Client	Hawthorn
Project	Portland, ME
Lead Designer	
Production Manager	Jason DiOrazio
Production Staff

Revision #	Sheet	Description of Change	A0.0 Dotted?	Assigned Date	Responsible Staff	Completion Date
6	A0.0	Added revision 6 to title block	Y			
	A0.1	Elevator Equipment room moved to rear of building. Wall type revised in Hall 148.				
		Rear doors revised to storefronts.				
		Standpipe cabinet added in core. Standpipe note added to Legend.				
	A0.2	Tv room windows removed and revised.				
		Standpipe cabinet added in core. Standpipe note added to Legend.				
	A0.3	Unit 323 revised.				
		Standpipe cabinet added in core. Standpipe note added to Legend.				
	A0.4	Standpipe cabinet added in core. Standpipe note added to Legend.				
	A1.1	Carports added. Parking spaces revised.				
	A1.7	Dtl 1 removed.				
	A1.8	Dtl 5 added.				
	A1.9	Dtl 7 added. Zip system note added and zip added to details.				
	A2.1	Elevator Equipment room moved to rear of building. Wall type revised in Hall 148.				
		Rear doors revised to storefronts.

DATE
8/28/2015
REVISED DATE
SHEET
M3.5

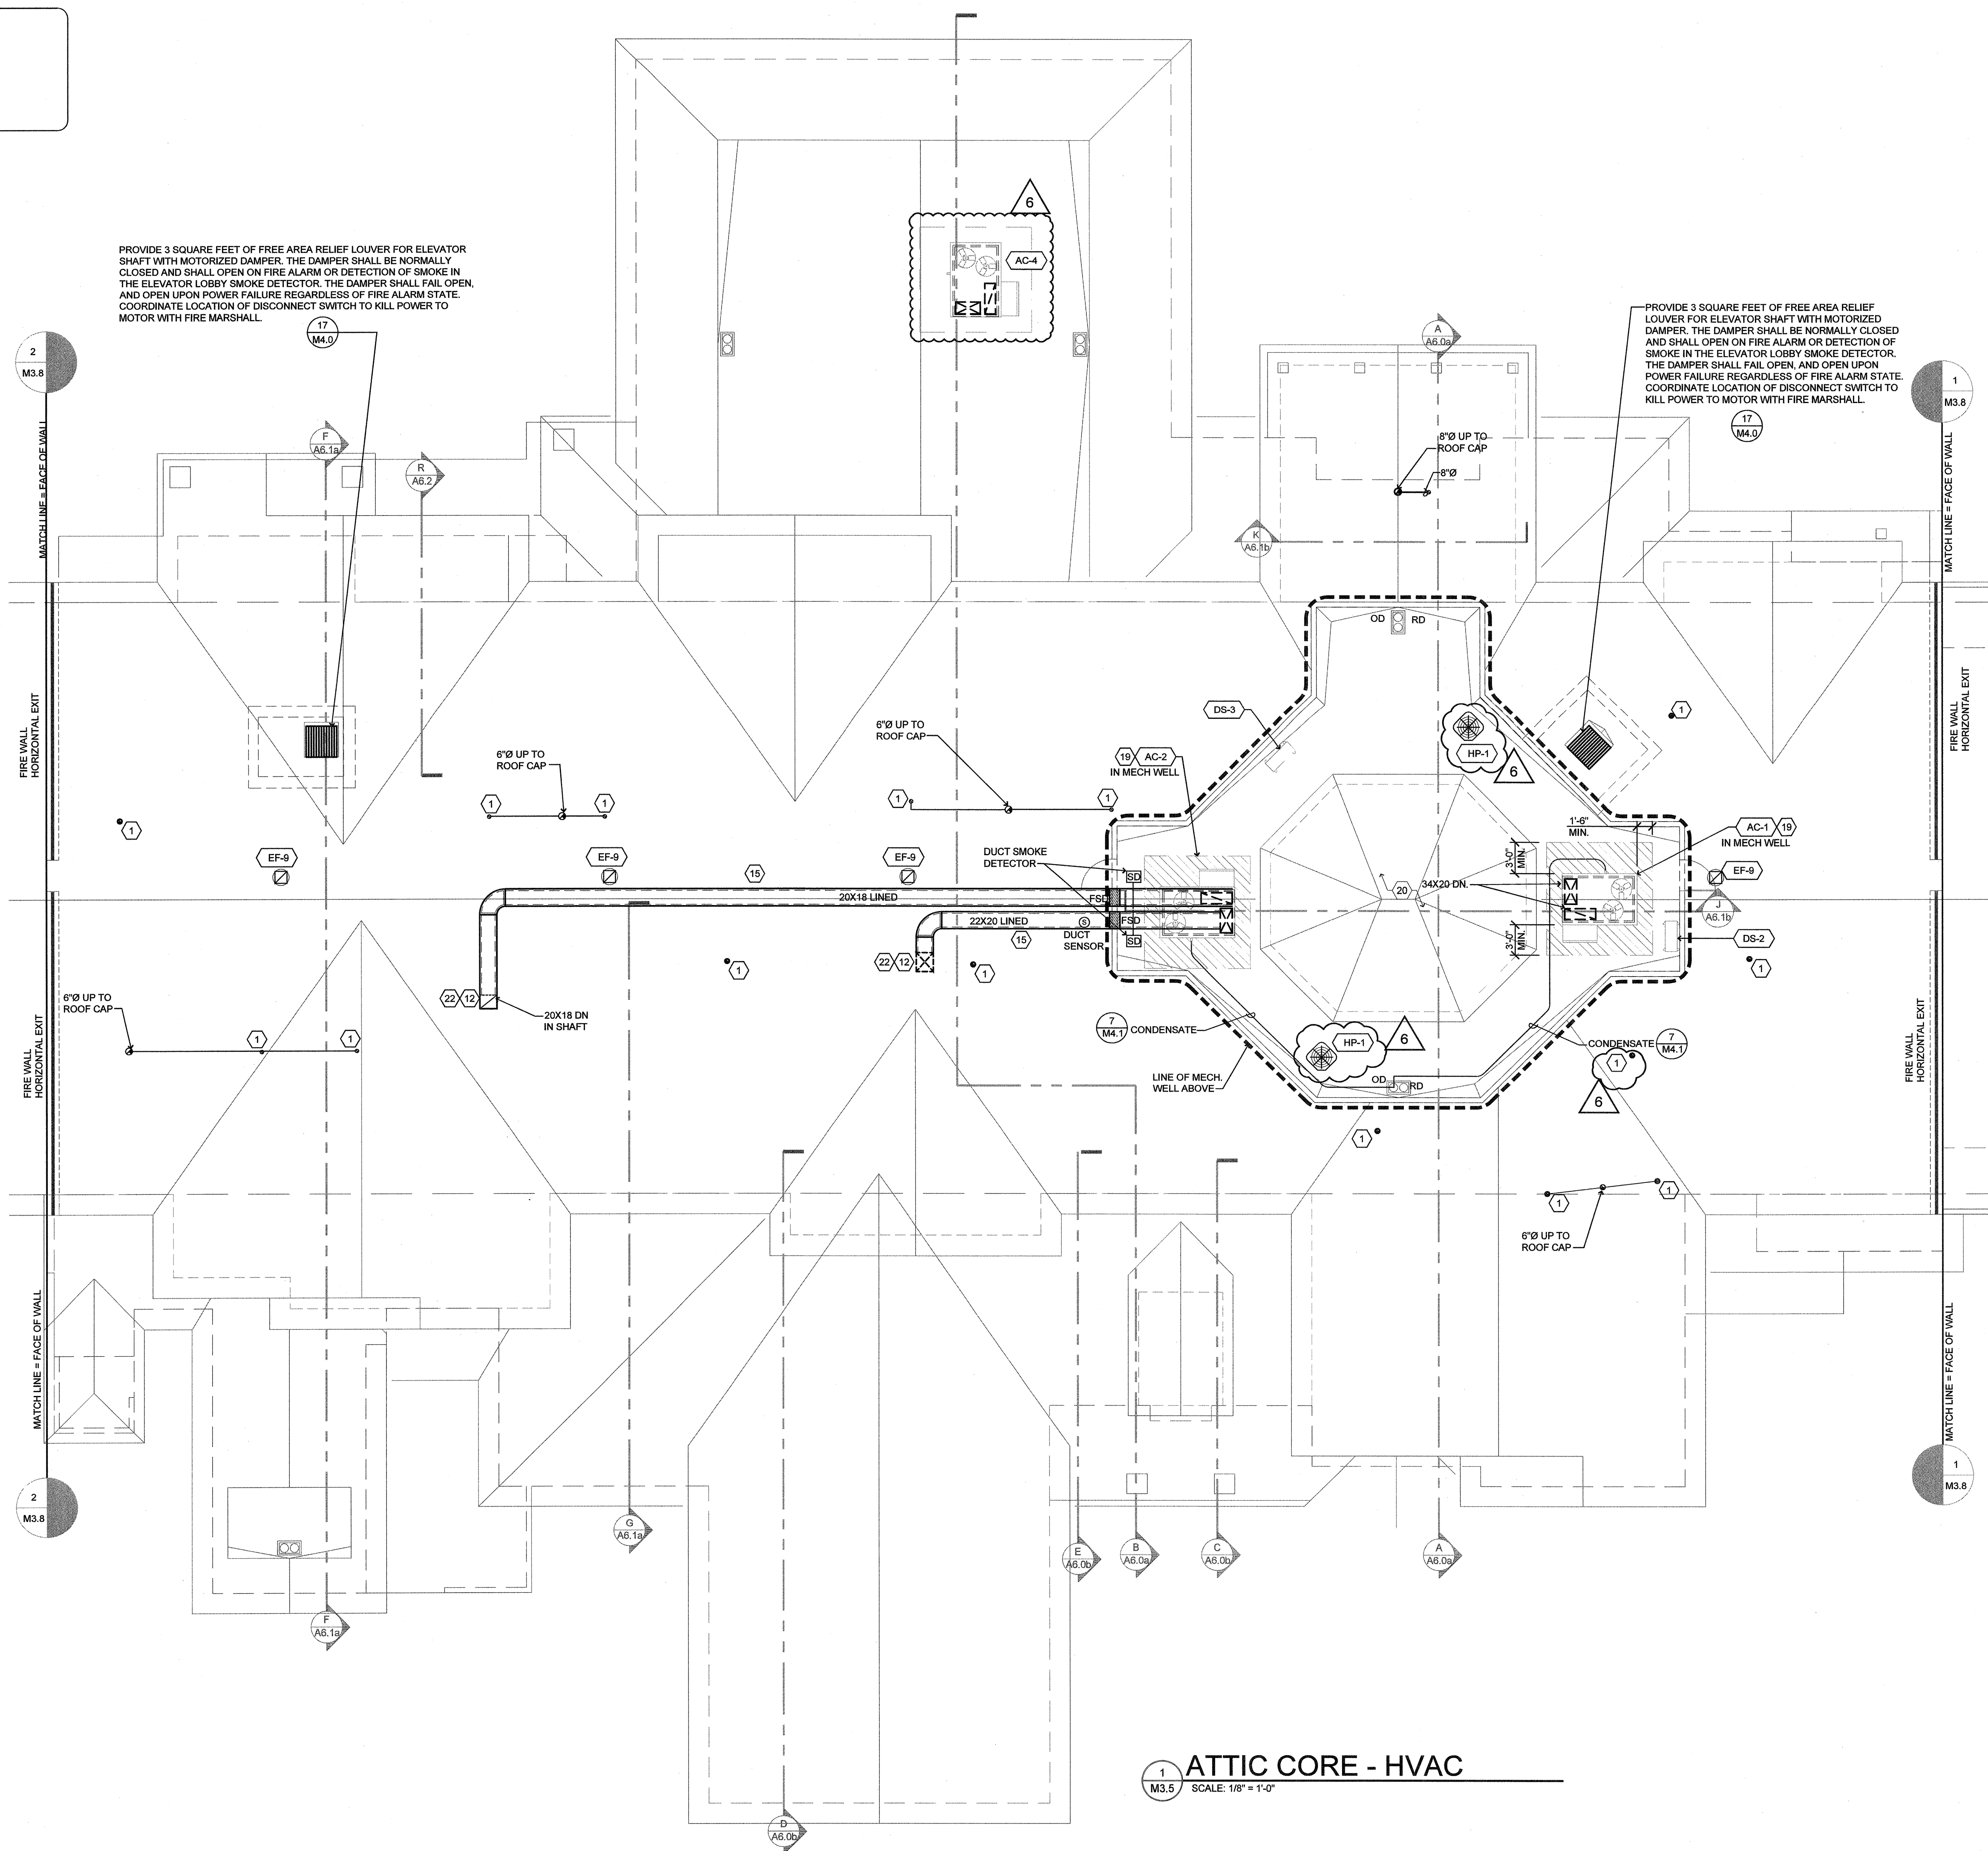
M3.4		Unit 401 CRD added. HVAC key note 31 added. PTAC note added.			
M3.5		Mech equipment above activity moved. Mech equipment added to roof.			
		HVAC key note 31 added. PTAC note added.			
M3.6		Louver added to Mech. Room. Laundry air transfer revised. Return duct added to all floors.			
		HVAC key note 31 added. PTAC note added.			
M3.7		Laundry air transfer revised. Return duct added to all floors.			
		HVAC key note 31 added. PTAC note added.			
M3.8		One exhaust duct removed.			
		HVAC key note 31 added. PTAC note added.			
M4.0		Dtl 5 added.			
M4.1		Dtl 12 removed.			
M4.2		HP-1 revised. EF-1a and EF-8a added. Dtls 1 and 2 revised.			
M4.6		Equipment revised.			
M5.1		Run Sprinkler pipe in soffit.			
M5.2		Section updated.			
E1.1L		Dimmers added. Rear Foyer door moved. Office 151 lighting revised.			
E1.2L		Dimmers added to Reading room.			
E1.7P		HP added to Mech. Well.			
E2.3b		Panel schedule revised. Gym HP-1 added.

6 DECK FRAMING (DECK BEAM) SCALE: 3" = 1'-0"

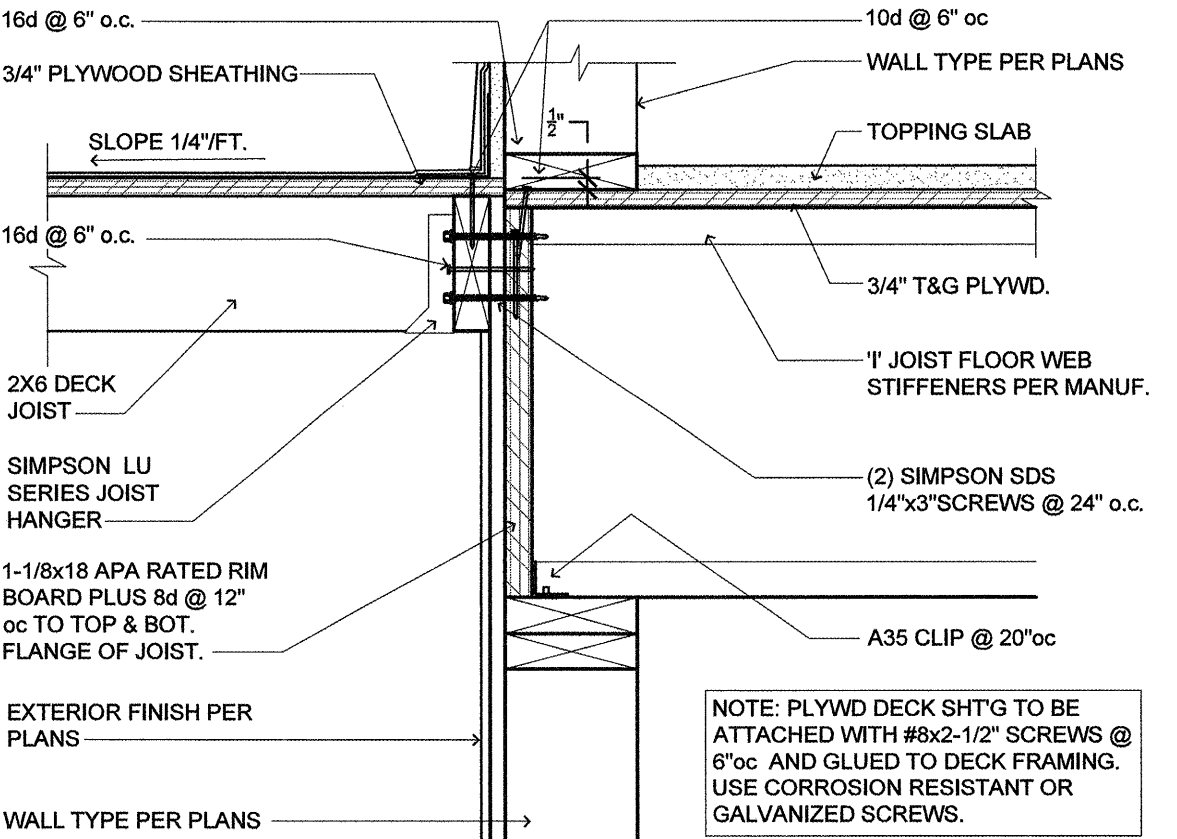
Units 201 and 202 revised joists.			
S1.10		Atrium walls revised.	Y		8/26/2016
S2.5		Dtl 12 revised.			
S2.9		Dtl 6 revised.			
S3.5		Dtl 14 added.			
M1.1		Grease inter. Revised. Plumbing in Media and Bistro area revised.			
M1.5		Core Plumbing revised.			
M1.6		Plumbing at corridor ends revised.			
M2.2		Dtl 1 and 2 revised.			
M2.3		P-22 removed in Plumbing Fixture schedule. Dtl 1 and 2 revised.			
M2.4		Dtls 7-9 added.			
M2.6		Elevator Equipment room moved to rear of building.			
		Rear doors revised to storefronts. Radon lines revised in Dining area.			
M3.1		Elevator Equipment room moved to rear of building. HVAC key note 31 added. PTAC note added.			
		Rear doors revised to storefronts. Kitchen duct work revised, Vents added. Grease exhaust revised.			
		Duct work in Activity moved.			
M3.2		Reading room duct revised. HVAC key note 31 added. PTAC note added. Unit 201 CRD added.			
M3.3		Gym and Exercise room mech. revised. HVAC key note 31 added. PTAC note added. Unit 301 CRD added.
